Regulatory, Planning and Assessment.MBisson/GMansfield
Reference: SDC2021/0004.02
Phone: 02 4974 2000

18 June 2021

15 GREENLEAF ROAD, KOORAGANG ORICA AMMONIUM NITRATE EXPANSION PROJECT (MP08_0129-MOD 6) - NEW AMMONIUM TANK

Figure 6 - Indicative schematic arrangement of proposed tank – elevation (Based on Yarwun design)

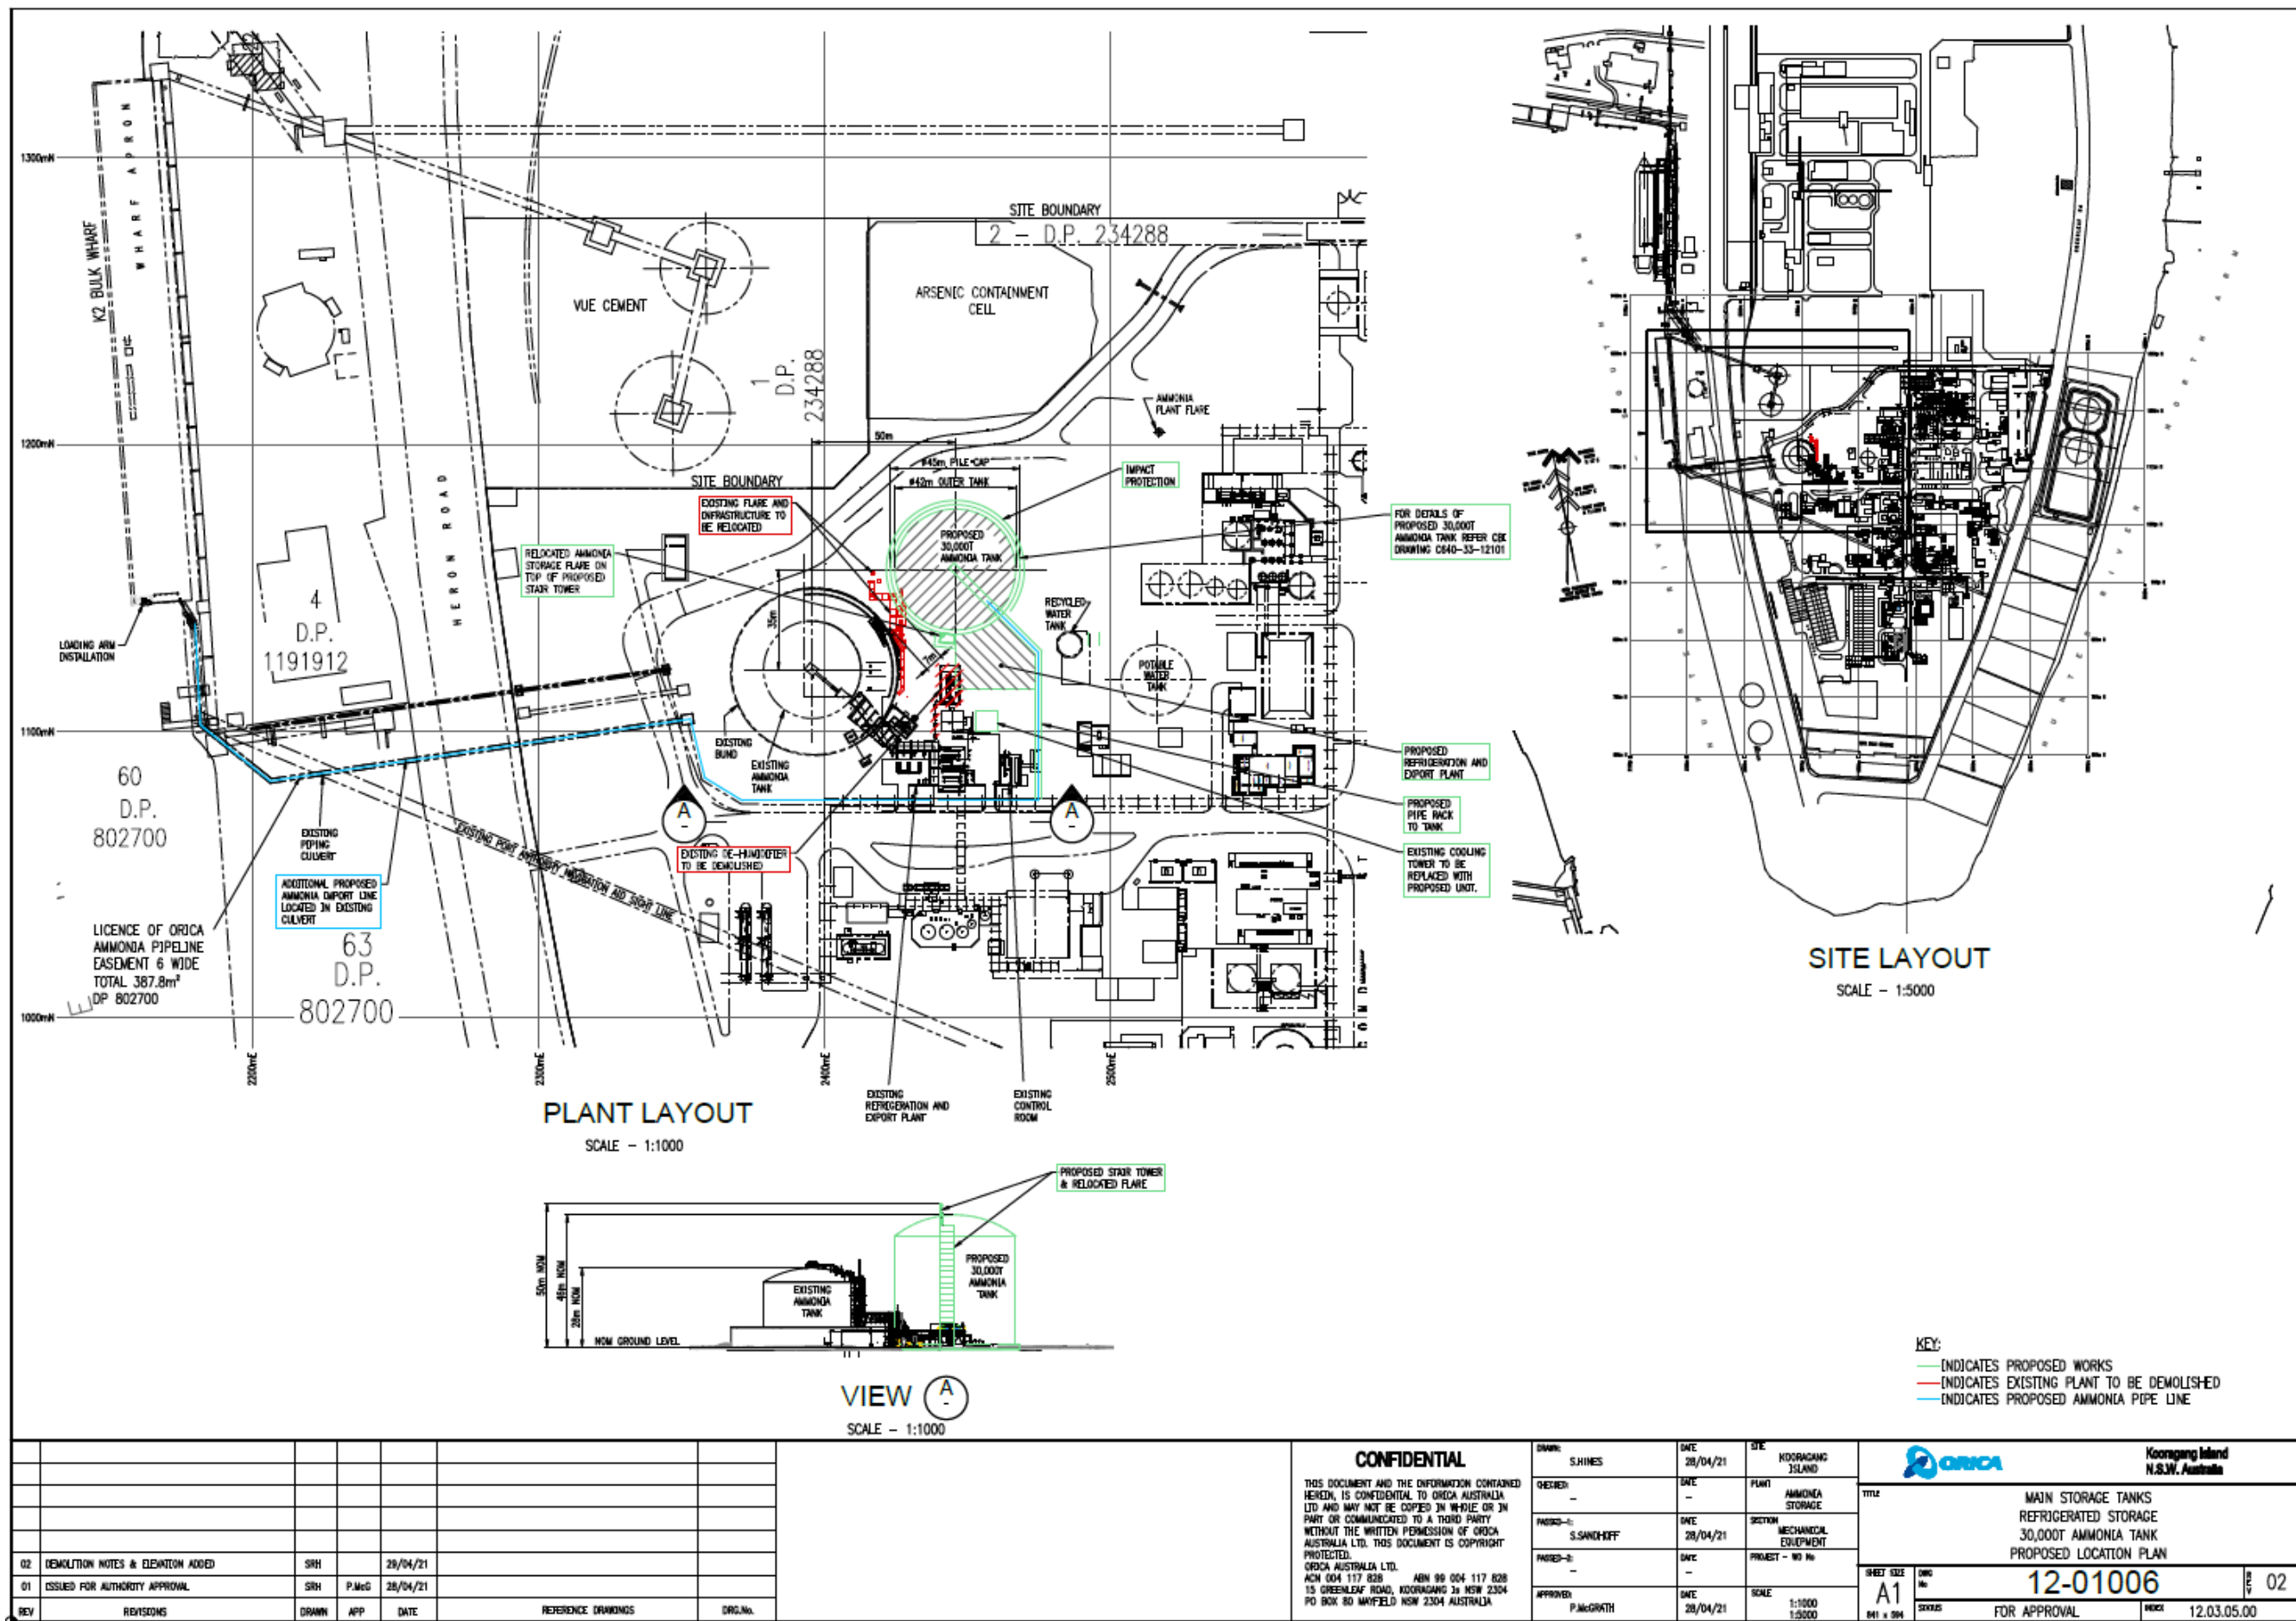
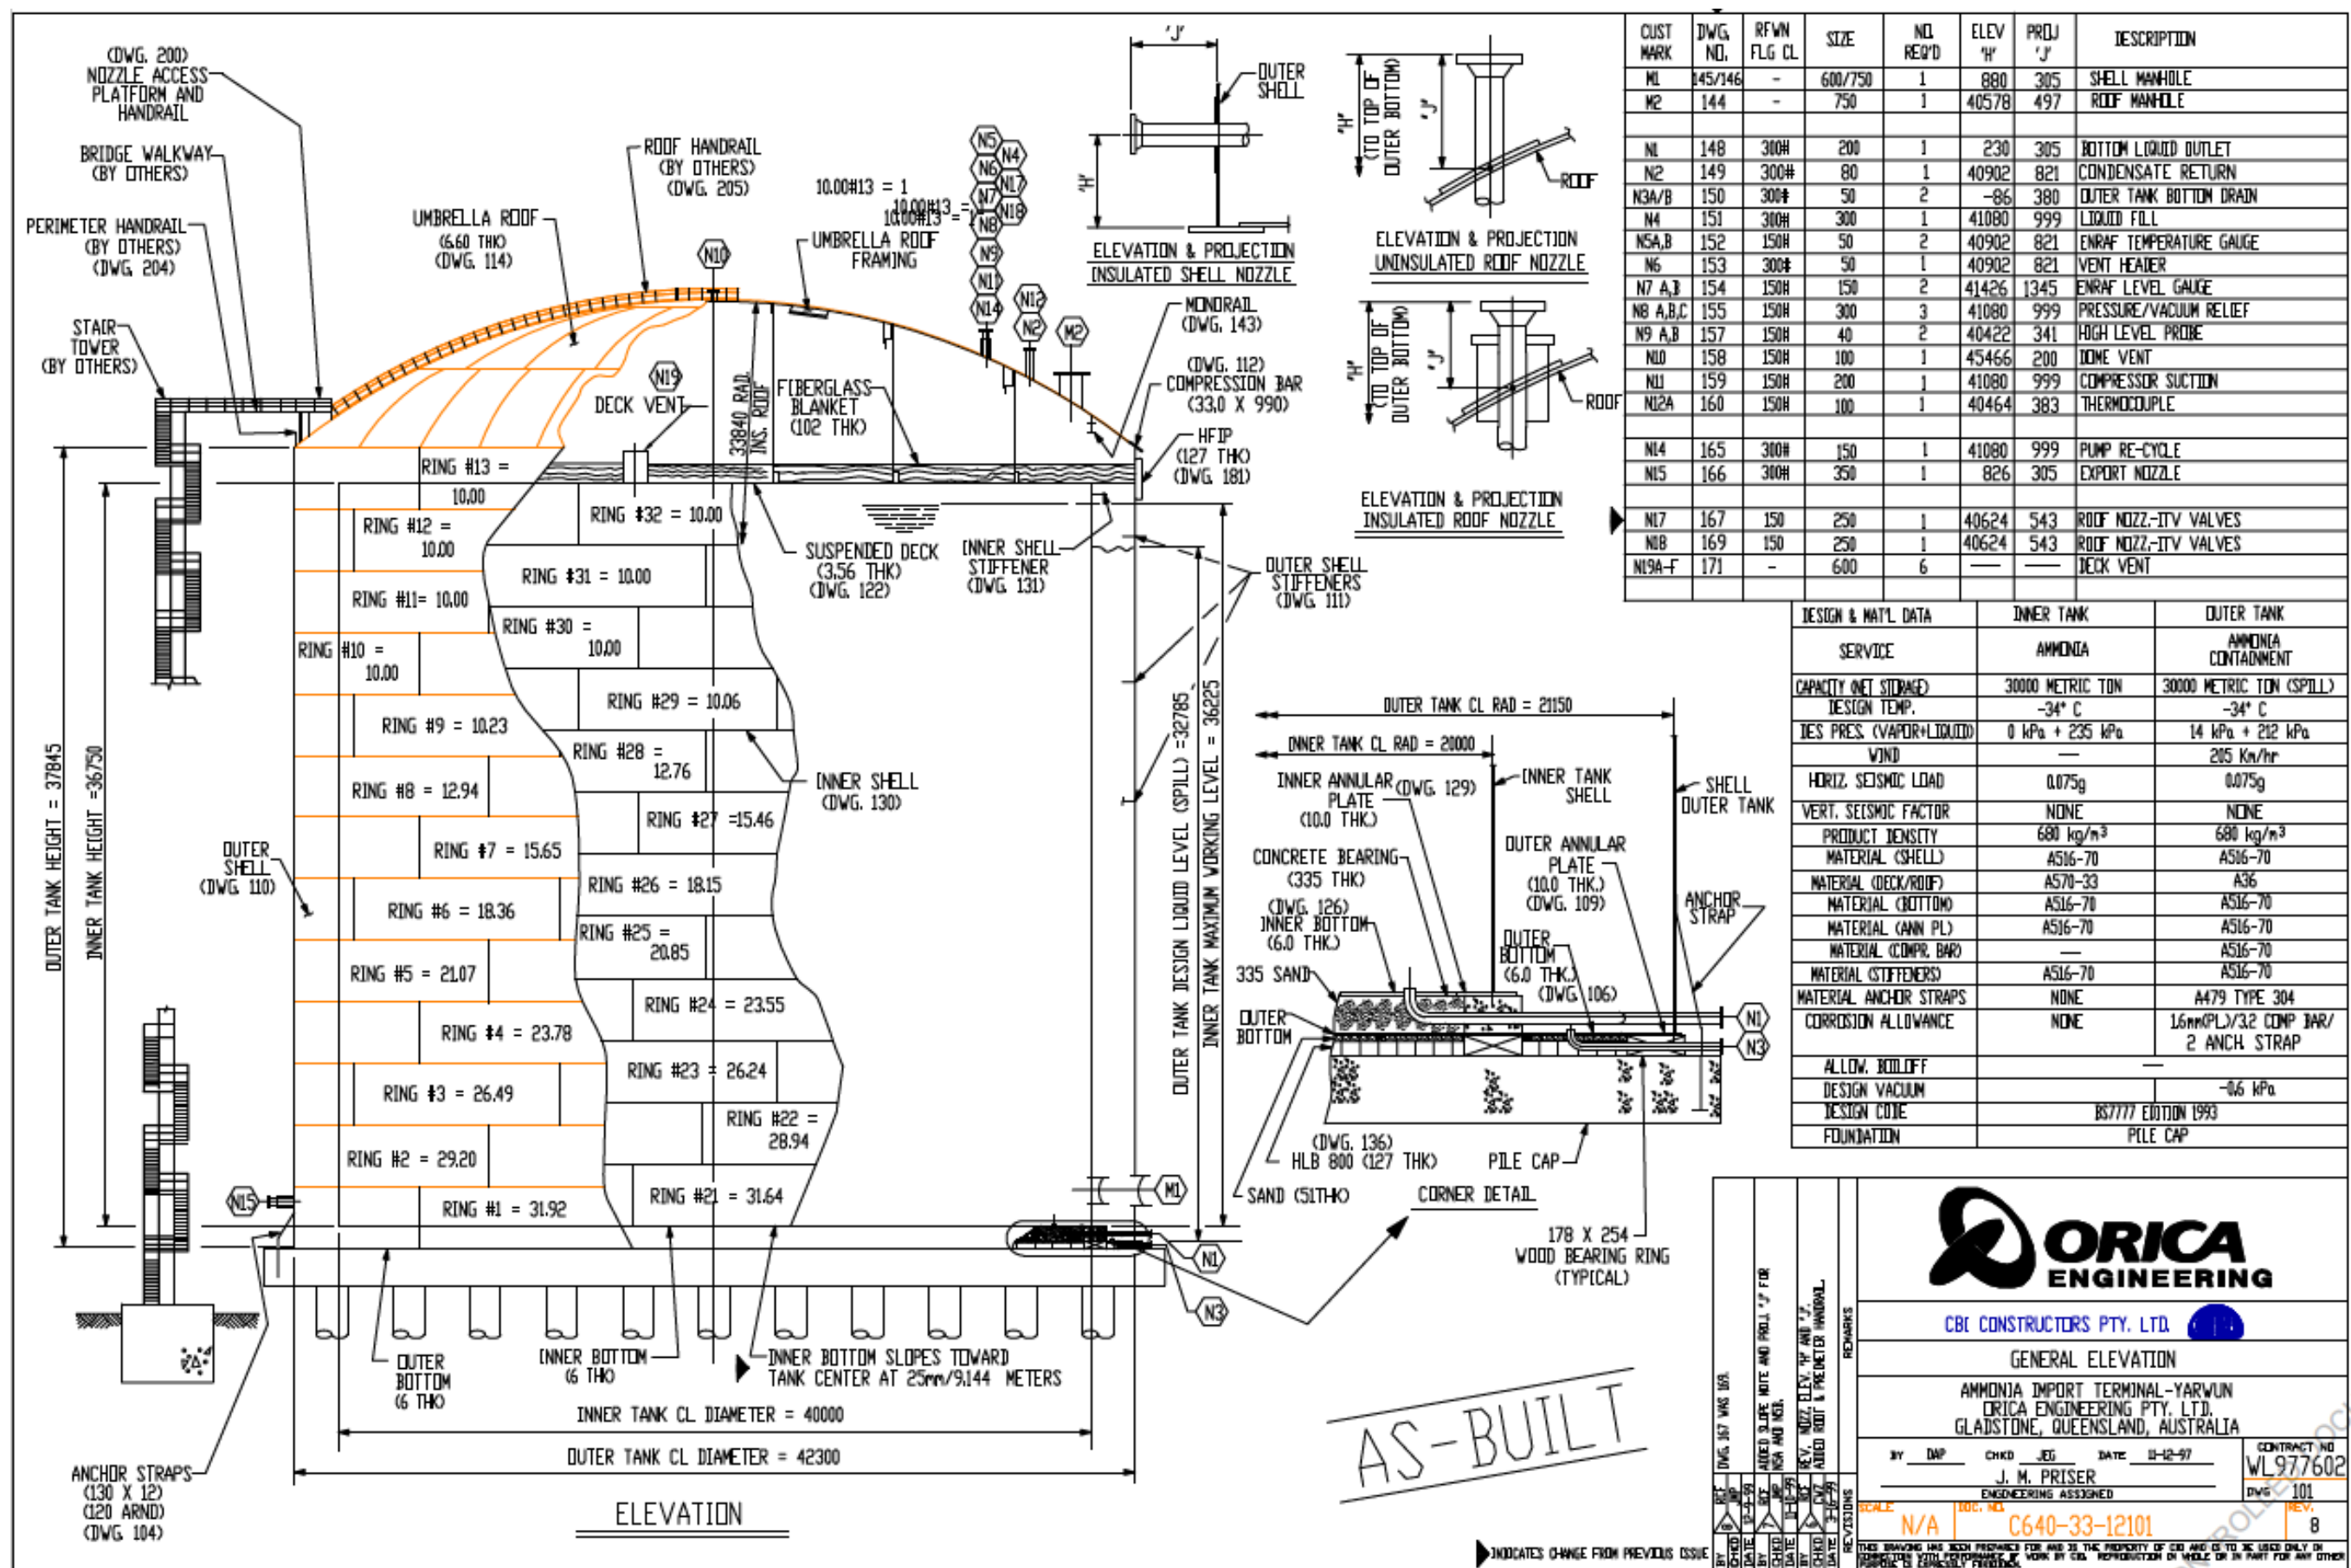
The project includes the installation of a 46m high ammonia tank and the installation of an upgraded ammonia storage flare as part of the stair tower structure to the new tank to a height of approximately 50m.

The subject site is located within the protected airspace of RAAF Base Williamtown and Newcastle Airport. The use of a mobile crane or installation of a structure having a height exceeding 30m above ground level on the subject site triggers the requirements of the publication 'The Operation of Cranes and Tall Structures in the Vicinity of Newcastle Airport' (Department of Defence, 2013). A copy of which can be found on CN's website at:

The Modification Application is to have regard to the requirements of the above document. For further enquiries about the document or the requirements the applicant should contact RAAF Base Williamtown by phone: 02 4034 7888 or email at WLM.ABCP@defence.gov.au.
